**PLANNING APPLICATION CONSULTATION RESPONSE**

| <b>Application Number:</b> | 3/2022/1000                                                                    |
| <b>Proposal:</b>           | Discharge of Condition 13 (Surface Water Drainage) of application 3/2021/0205. |
| <b>Location:</b>           | Land at Neddy Lane, Billington, BB7 9LL                                        |

Development	BILLINGTON		
Location	NEDDY LANE		
Marketing Name	CALDER GRANGE		
Drawing Title	DRAINAGE LAYOUT		
Drawing Number	4441 / Eng / 001-3	Revision	E
Drawn By	CLB	Scale @ A1	1:500
Checked by	-	First Issue	20.04.21

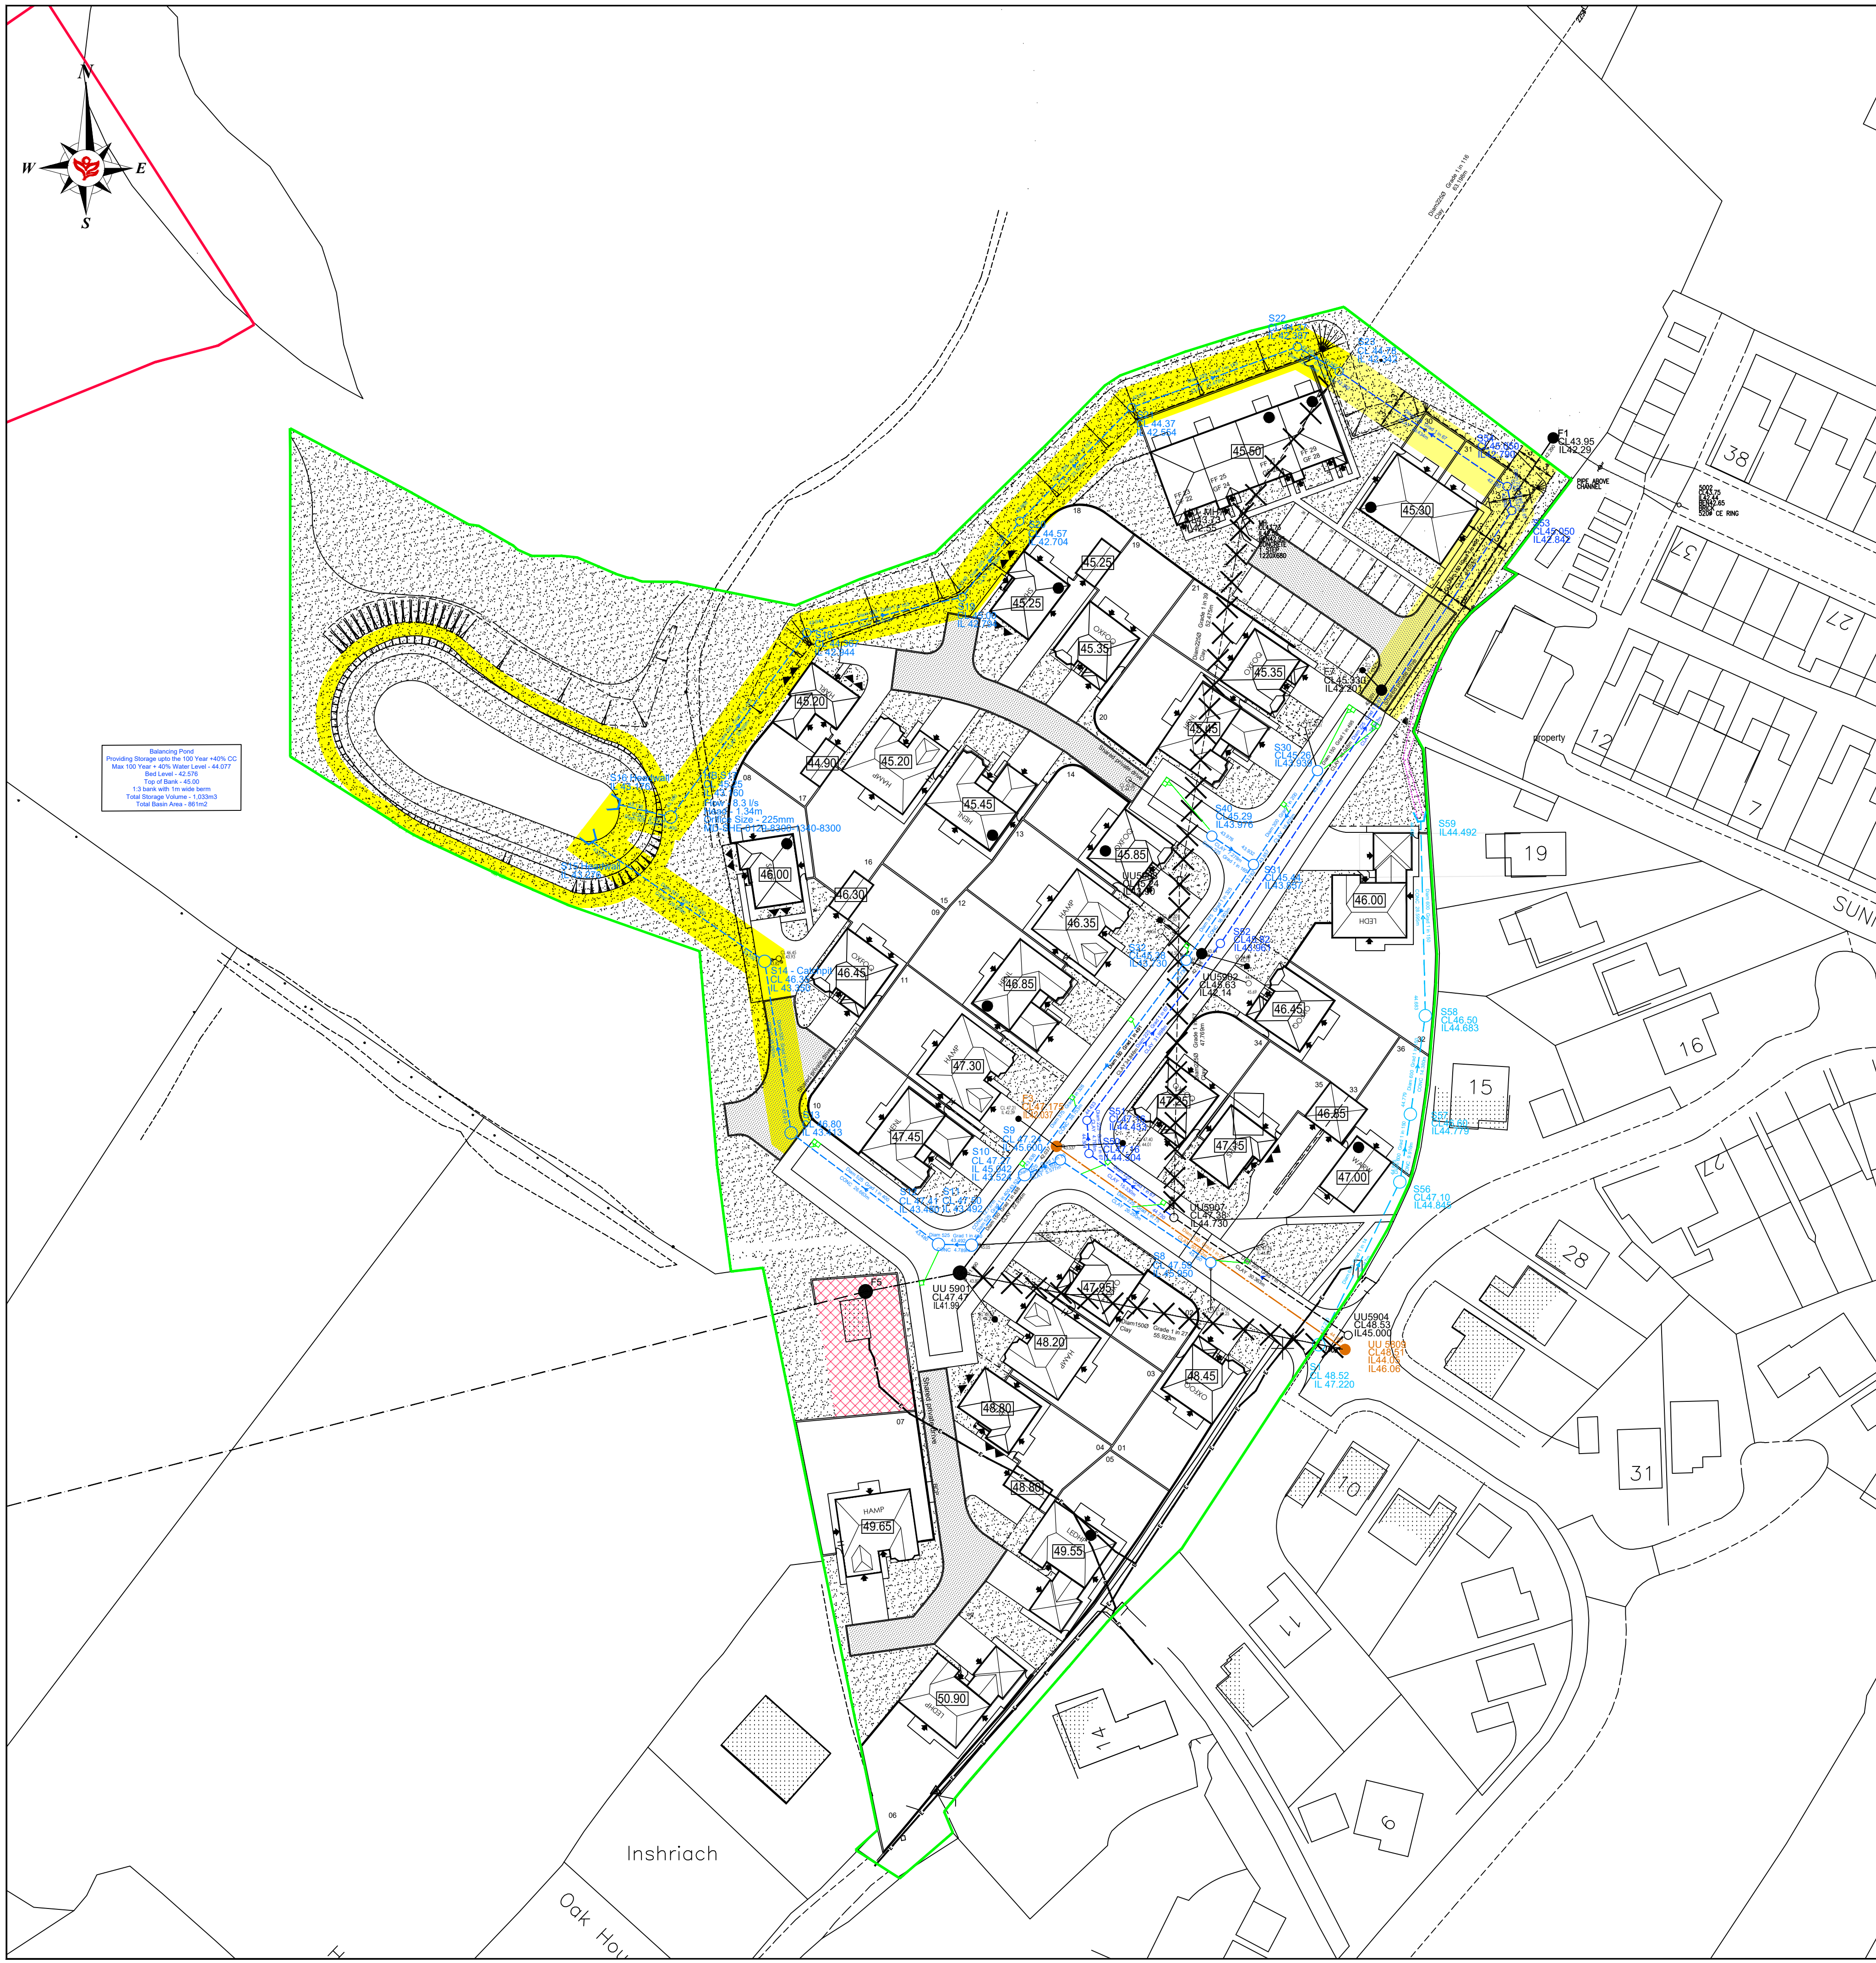
The Lead Local Flood Authority makes reference to the diversion of the surface water sewer under the section185 agreement with United Utilities, the plans show that the

diversion passes through the rear gardens of two properties in the north, this could have an associated risk as a result of management and maintenance in perpetuity.
